ENGLISH HERITAGE
NORTH WEST OFFICE

Our ref: L00238823

**Notifications under Circular 01/2001, Circular 08/2009 &
T&CP (Development Management Procedure) Order 2010
PARK HOUSE FARM, BOLTON BY BOWLAND, LANCASHIRE, BB7 4LA
Application No 3/2013/0294**

PARKHOUSE FARM
BOLTON BY BOWLAND
GROUND FLOOR LAYOUT
SCALE 1:50 @ A3

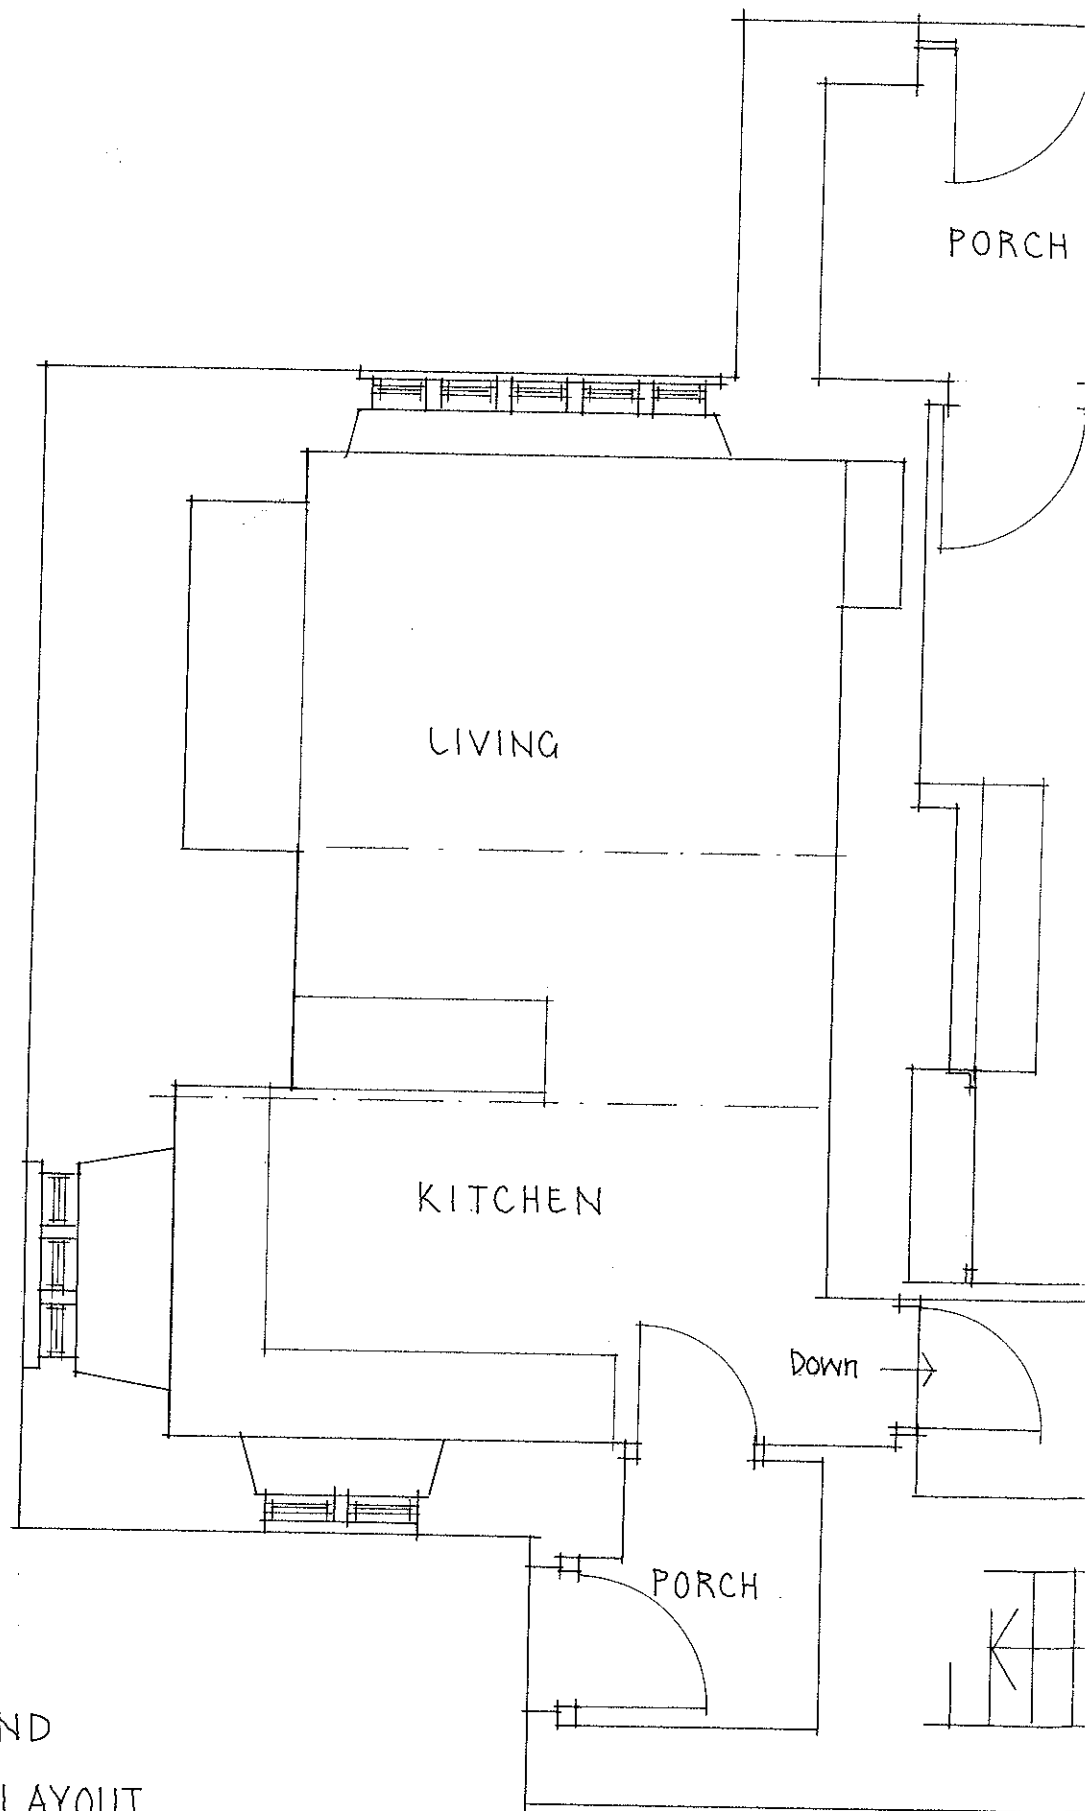
A key feature of traditional farm buildings is the use of 'breathable' materials in their construction. Permeable materials coupled with the good ventilation inherent in most traditionally constructed buildings allows moisture to escape without causing damage to the building fabric. Serious damage can result from the use of incompatible materials that restrict this ability of the building fabric to 'breathe'. We are therefore concerned about the use of a damp-proof membrane and the use of Carlite Bonding and a gypsum multifinish plaster to correct issues created by damp. We also are not comfortable with the replacement of defective timber flooring with concrete. These

materials and techniques would create a barrier to the movement of water leading to long term damage to the fabric of the building. Repairs should be like for like using traditional methods and be made by a skilled and experienced practitioner.
